Your Ref: 2024/92842
Our Ref: A005110

1st November 2024

Land to North and South of, Crossley Lane, Dalton, Huddersfield - Discharge of details reserved by condition 3 (drainage) of previous Reserved Matters approval 2020/90805 pursuant to outline permission 2015/90430 for erection of residential development comprising (Use Class C3) and incorporating associated new access (to Crossley Lane and Cold Royd Lane) and associated works (122 dwellings)

TITLE	SECTION 104 LAYOUT PARCEL 5		
PROJECT	CROSSLEY LANE HUDDERSFIELD		
CLIENT	MINERVA WORKS DEVELOPMENTS LTD		
DRAWING STATUS	PRELIMINARY		
Scale	1:500 @ A1	Date	JAN 24
Drawn	DJG	Chk.	MI
Dwg. No.	0906/03/03		Rev /

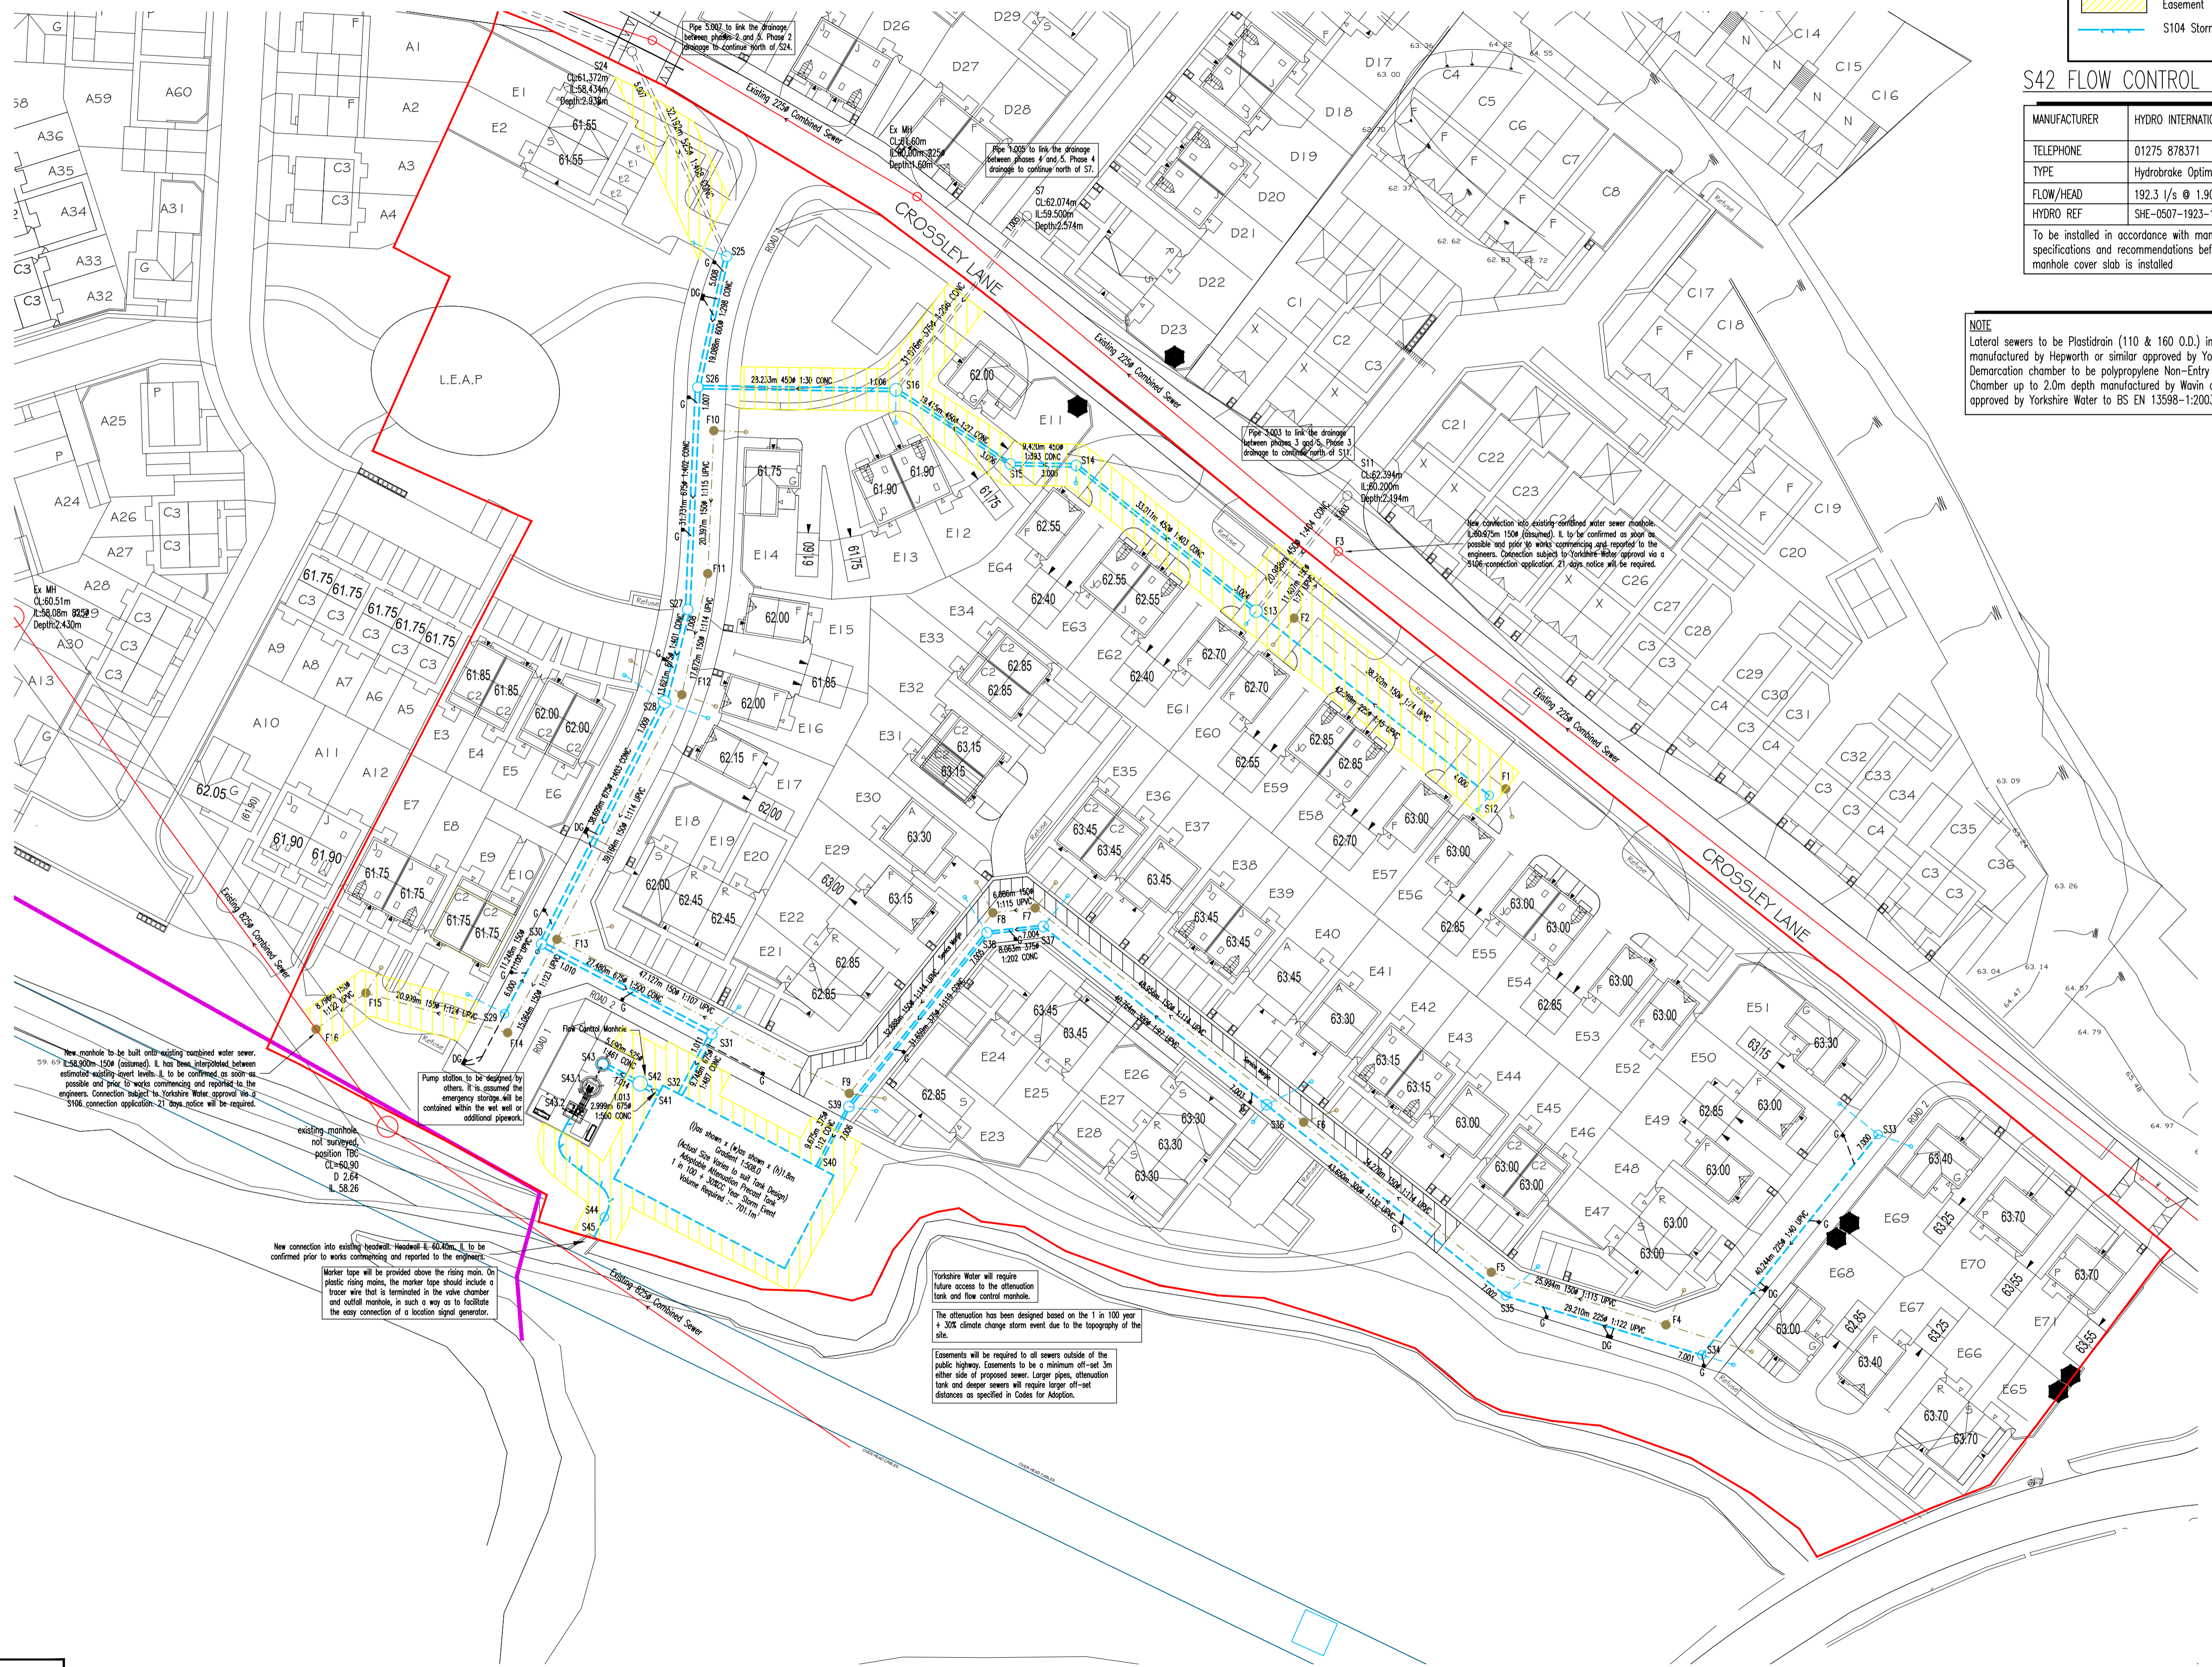
Yorkshire Water has no objection to the discharge of condition 3.

'Section 104 Layout Parcel 5' 0906/03/03/ dated 26/01/24 as prepared by ARP should foul water to discharge to combined water sewer. Surface water will discharge to watercourses.
